REDTAIL RANCH

FINAL PLAT

LETTER OF INTENT – FINAL PLAT

DECEMBER 2018

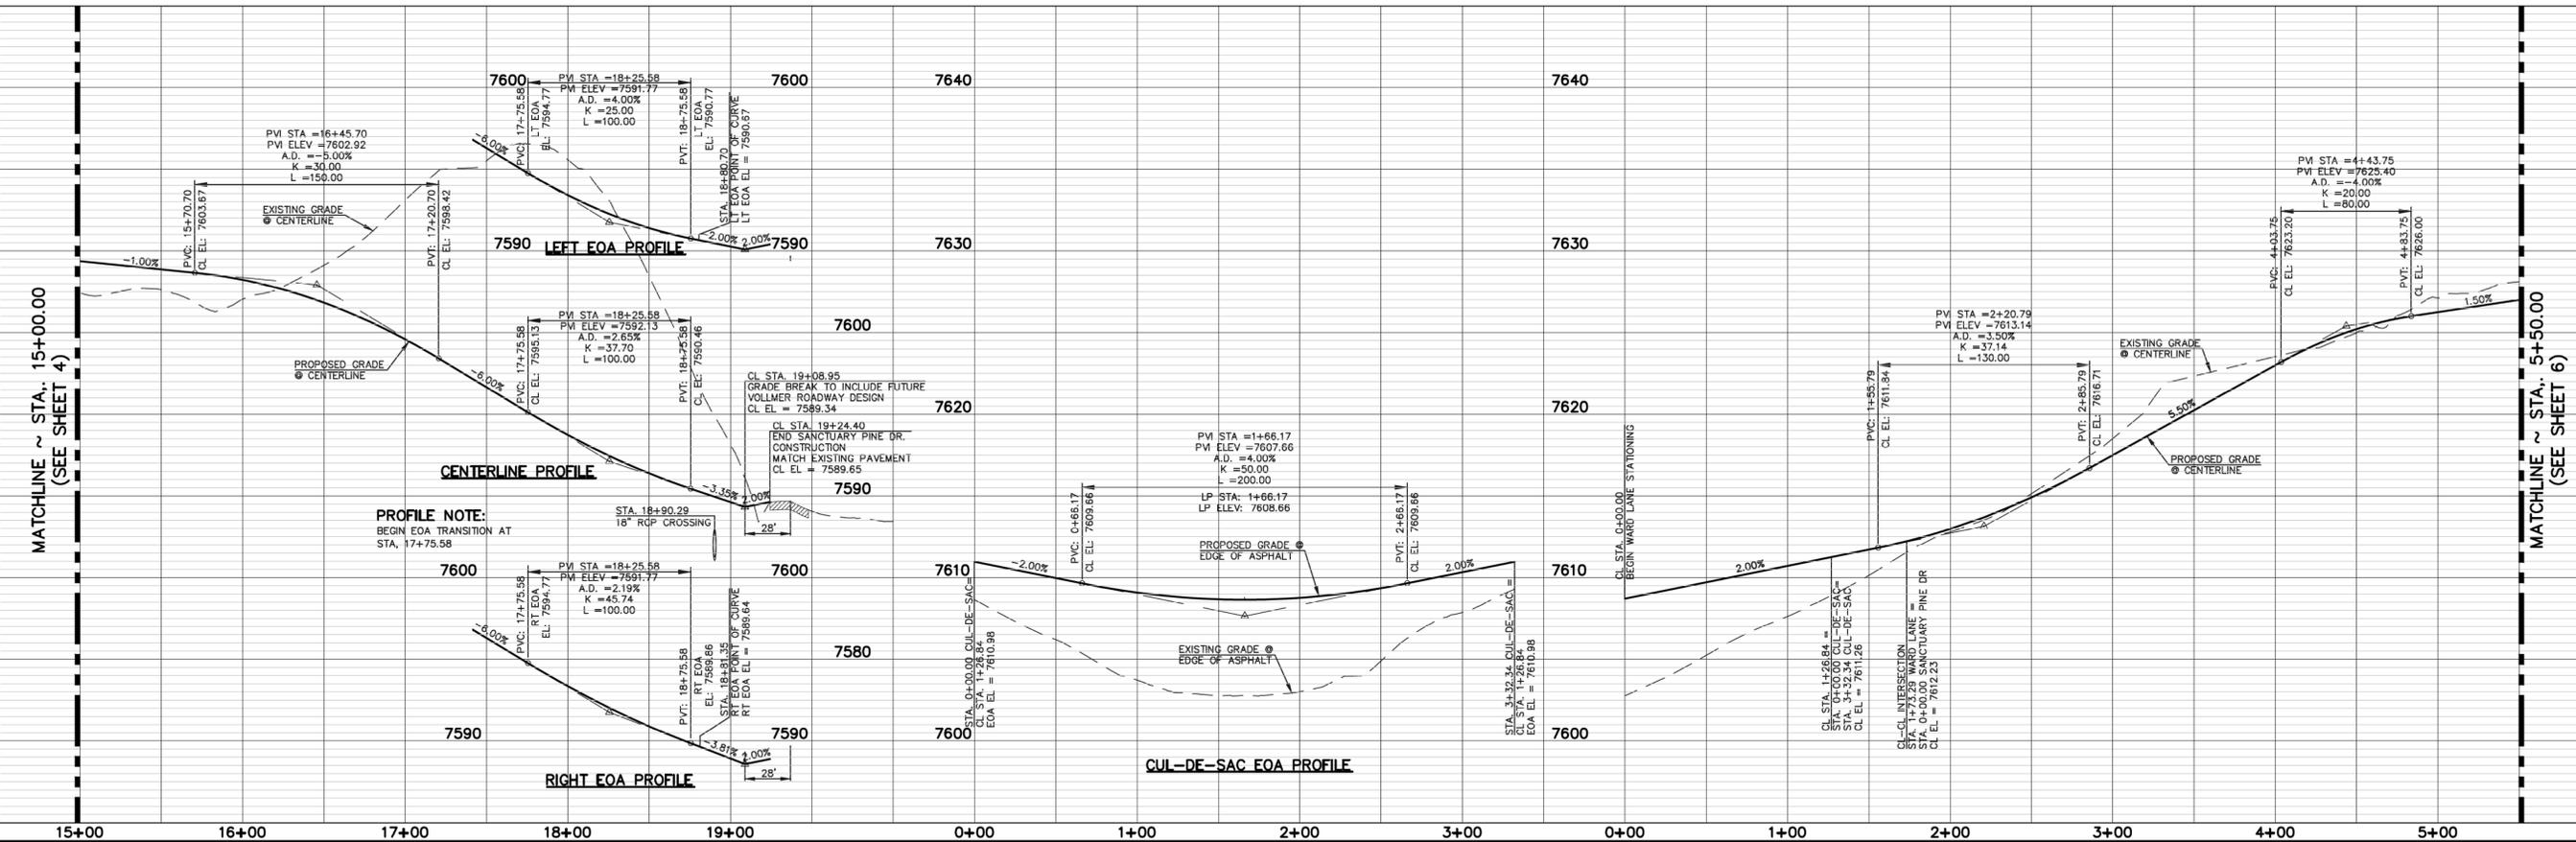
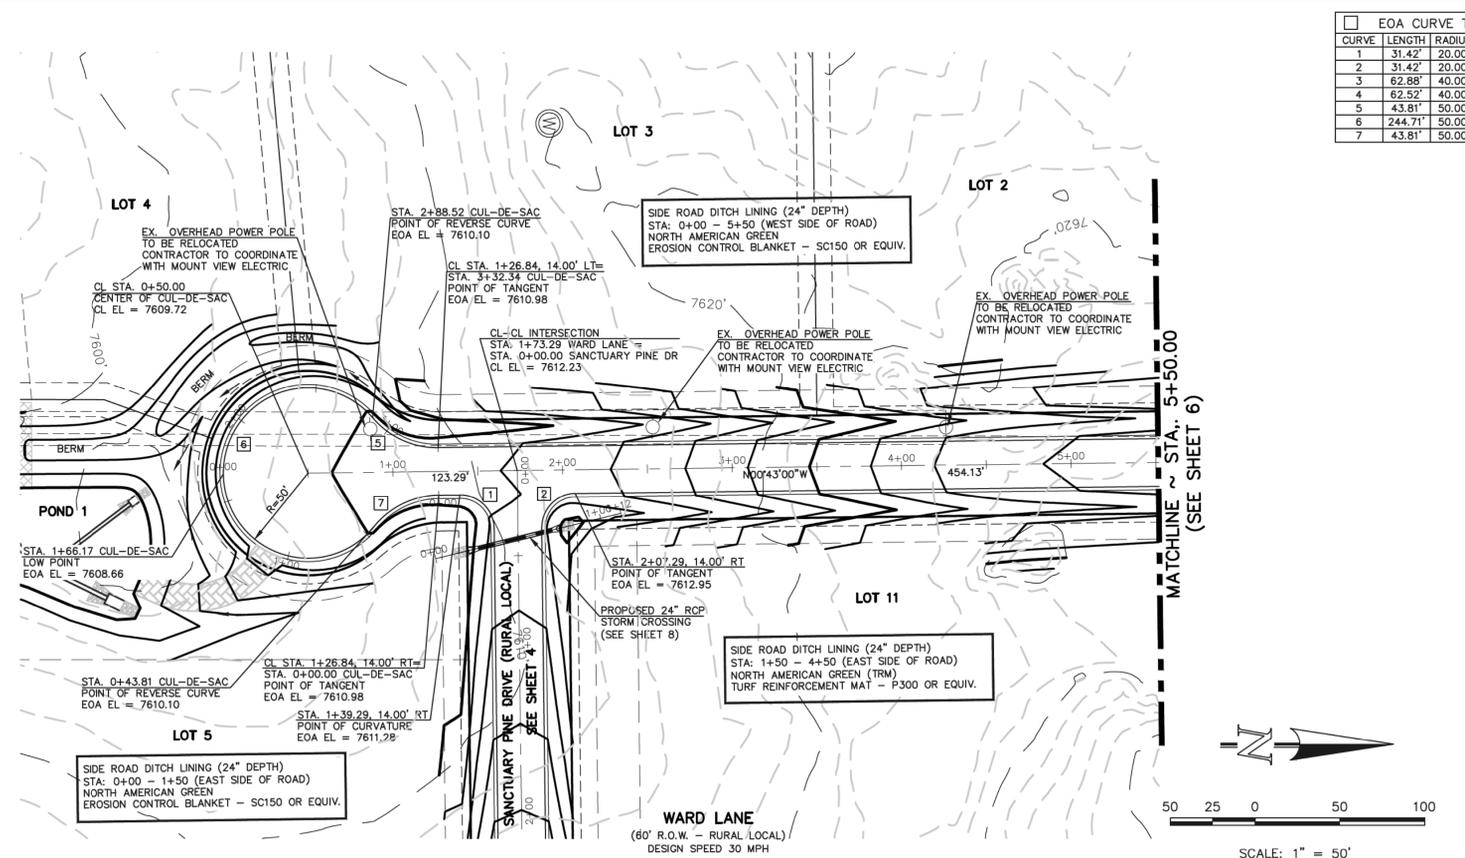
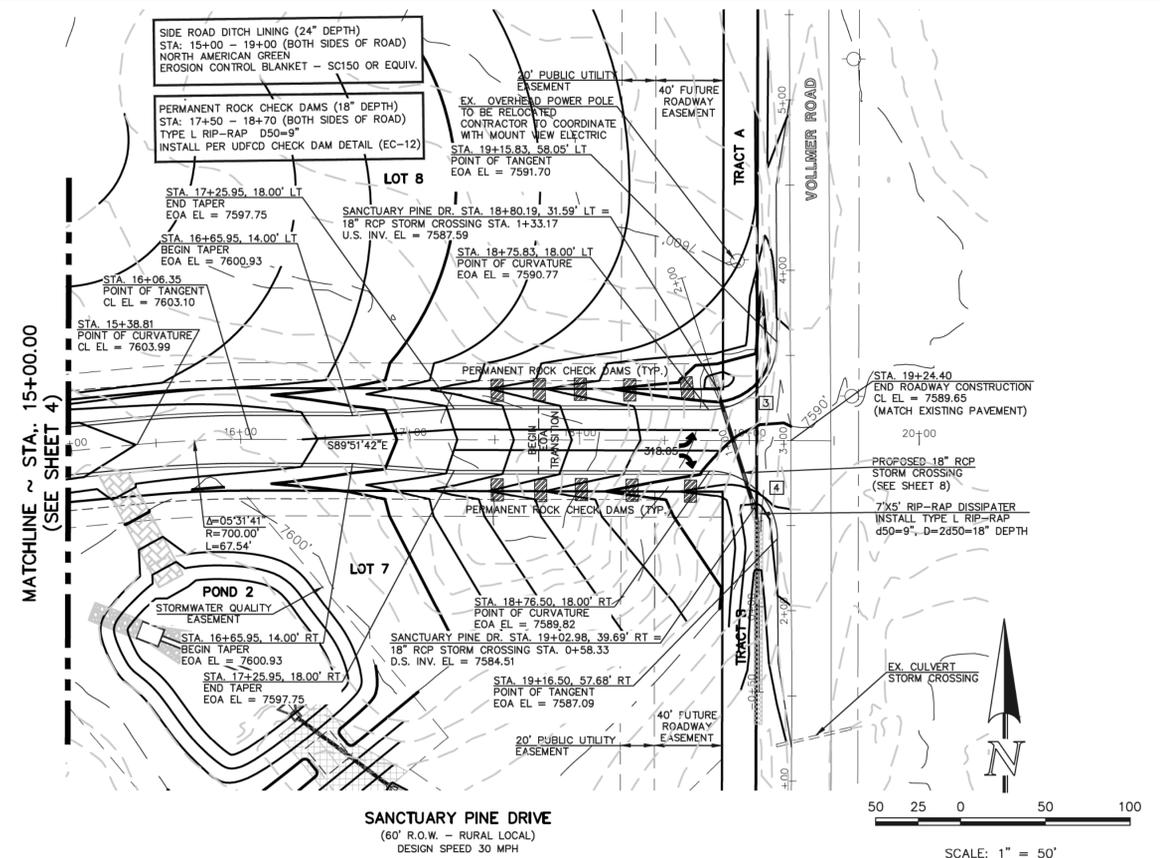
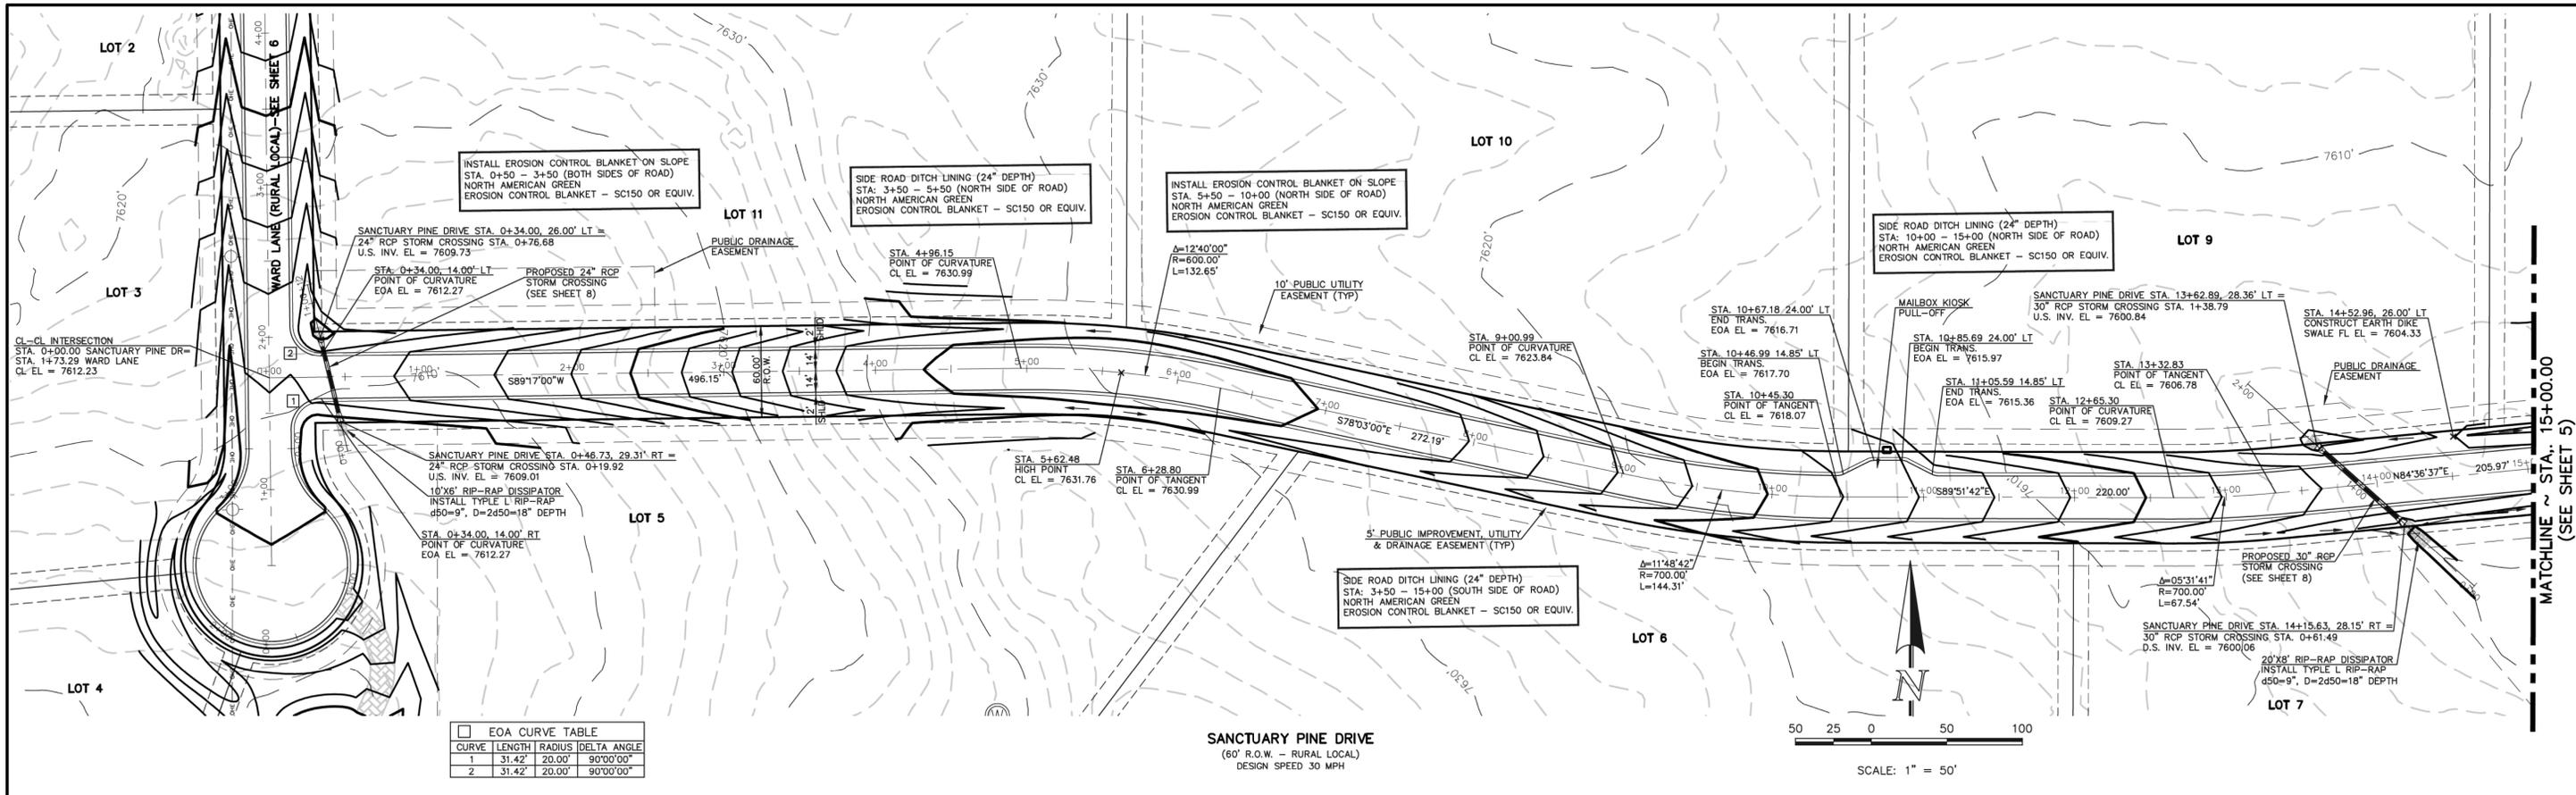
Add permanent sediment control for east end of Sanctuary Pine Dr.

Language added to LOI. Sediment control is addressed in CDs.
